Consultee Comment for planning application 19/02465/LB

Cedar Lodge, North Side, Steeple Aston
19/02465/LB
Creation of a jib door and associated stair

Cedar Lodge, North Side, Steeple Aston
19/02465/LB
Creation of a jib door and associated stair

The phasing plan illustrates this history.

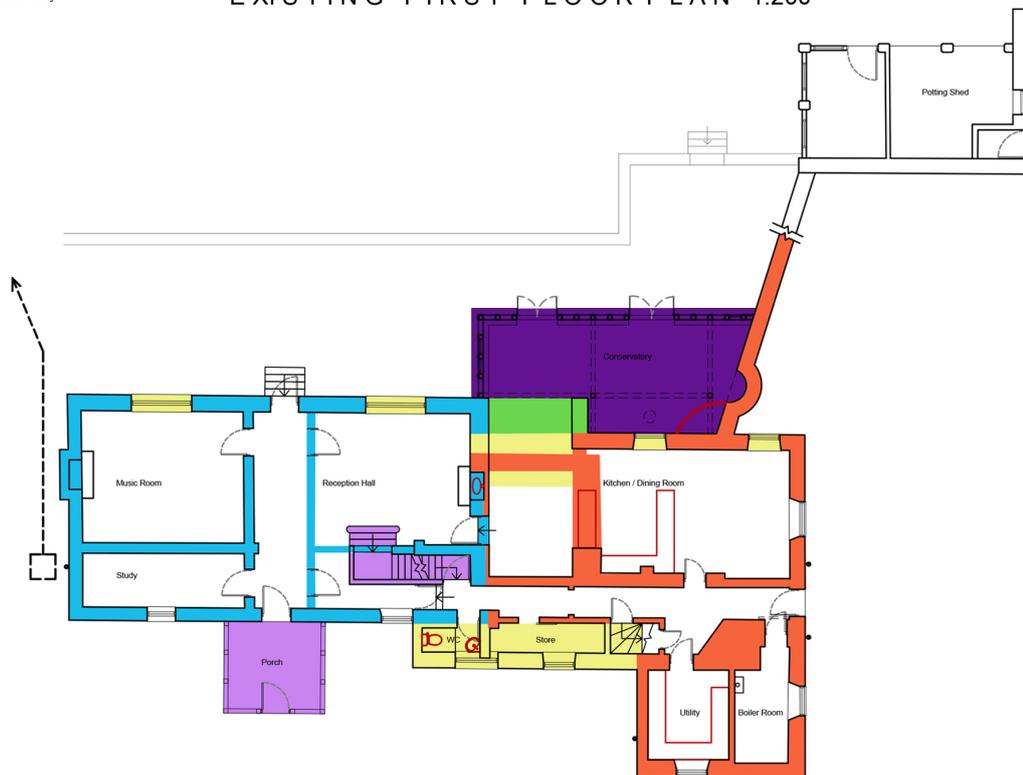
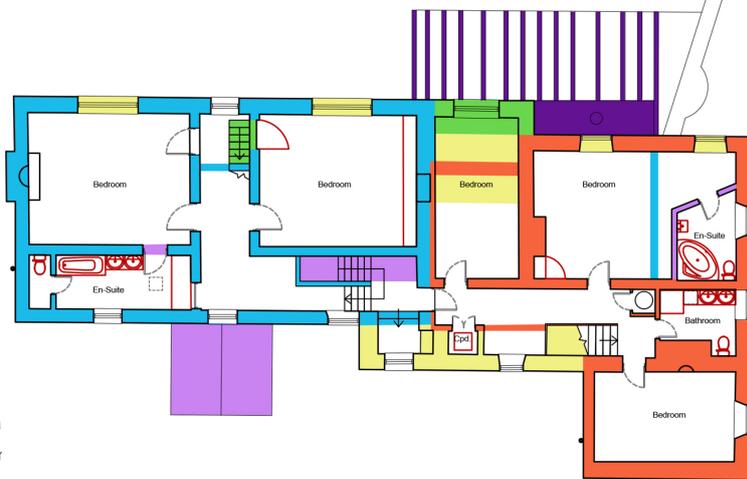
The report provides a very useful phasing plan, but does not fully address the issue of the blocked window which is located on the gable end wall of the principal house which was revealed during opening up works to the ceiling in the 'service wing' of the building. It is unlikely that a window would have been inserted into the wall if there was an existing building in that location. There is mention of a service yard in the new report, but it is unclear if this refers to the area in question.

The report provides a very useful phasing plan, but does not fully address the issue of the blocked window which is located on the gable end wall of the principal house which was revealed during opening up works to the ceiling in the 'service wing' of the building. It is unlikely that a window would have been inserted into the wall if there was an existing building in that location. There is mention of a service yard in the new report, but it is unclear if this refers to the area in question.
